2023/0585

Address: 5 Wainwright Place, Wombwell, S73 8LY

Description: Two Storey Side Extension

Drawing Title **PROPOSED PLANS**

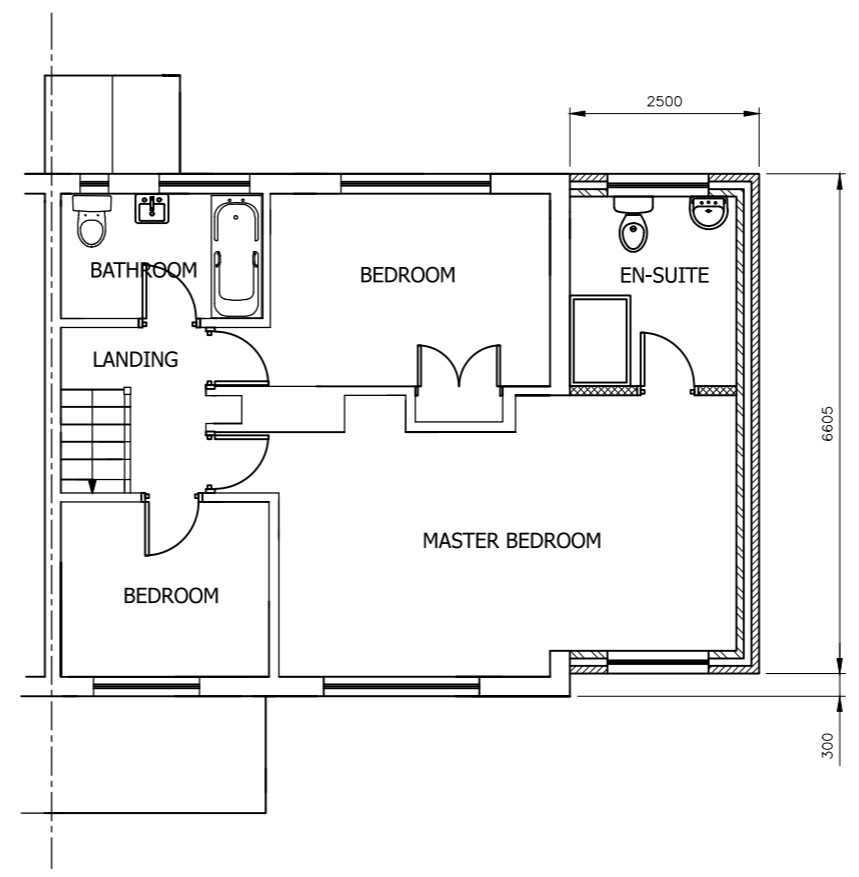
Tiles and brickwork are proposed to match the existing materials of the dwelling. Windows shown on the elevation plans appear to match the style and size of those already installed. The proposed extension would have a side projection of 2.5m, which is less than half of the existing width of the dwelling.

Drawing Title
PROPOSED ELEVATIONS

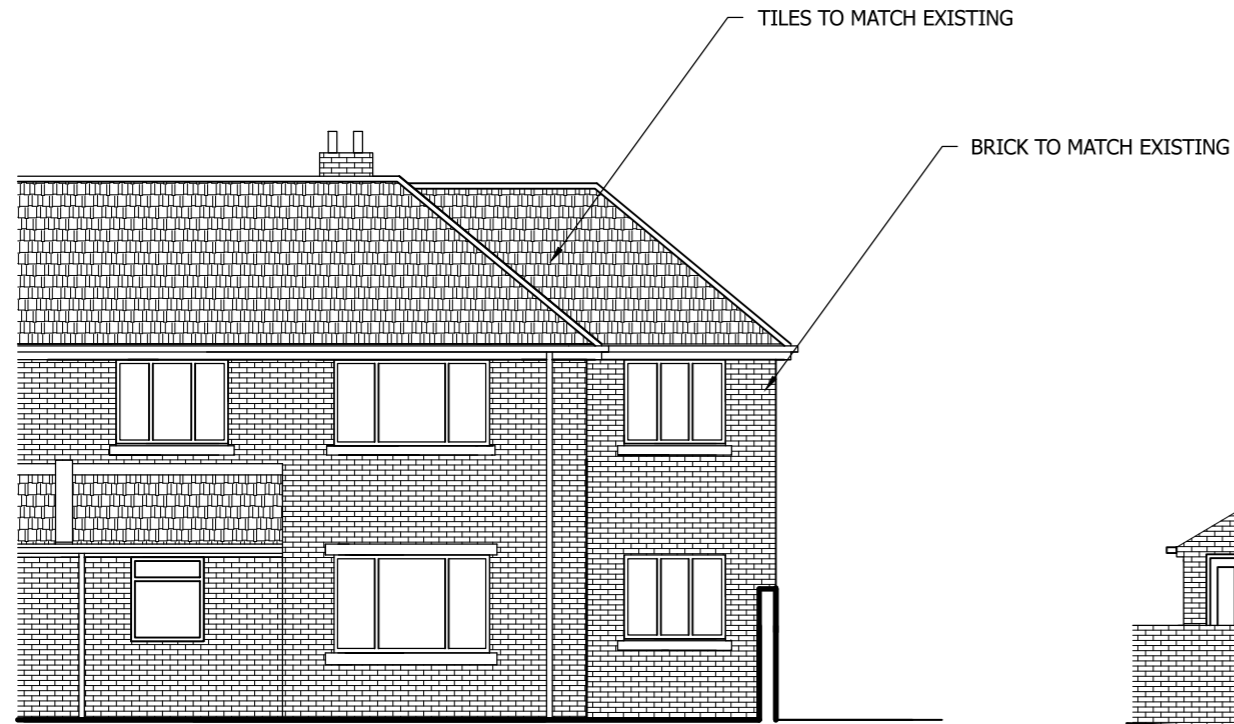
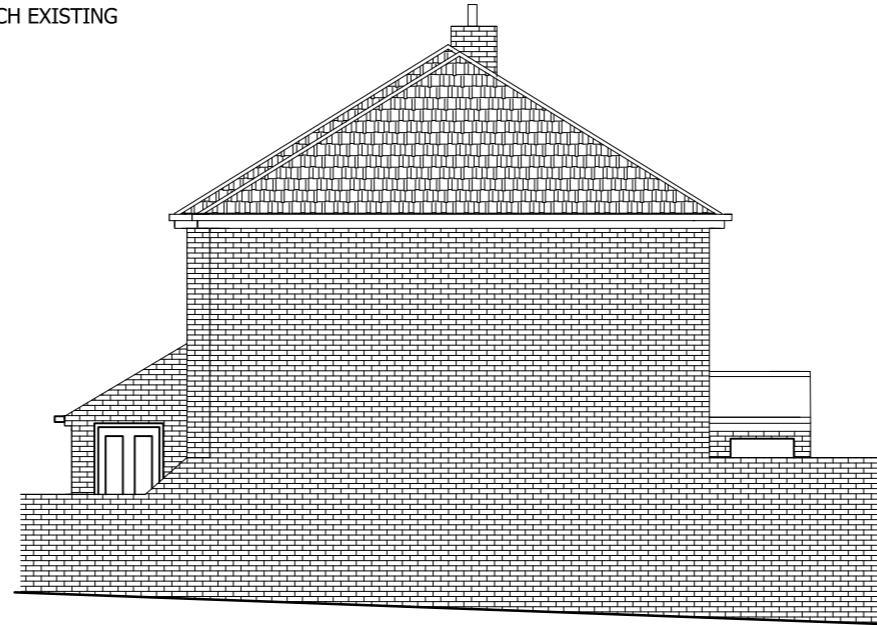
The proposal is for a two-story side extension in replacement of the existing lean-to extension. The proposal is similar to that refused in application 2023/0040. However, in contrast to the previous application, a small set back has been included on the front elevation and the extension's roof design has been adjusted. The whole of the ground floor is proposed to be used as a store, with direct access through a rear garage style door leading into the garden. On the first floor, a bedroom is planned to be extended and a new ensuite bathroom installed. One new window on the ground and first floor front elevation are proposed, along with a single first floor window on the rear elevation. No side widows are proposed.

The plans have been amended from those previously refused to include a setback on the front elevation of 300mm and the proposed roof design has also been altered. Together, and although the setback does not meet the setback guidance outlined in SPD House Extensions and other Domestic Alterations, the proposal does appear subordinate to the original dwelling. Furthermore, the extension does not harm the original character of the dwelling and does not have a negative impact with the immediate or broader street scene.
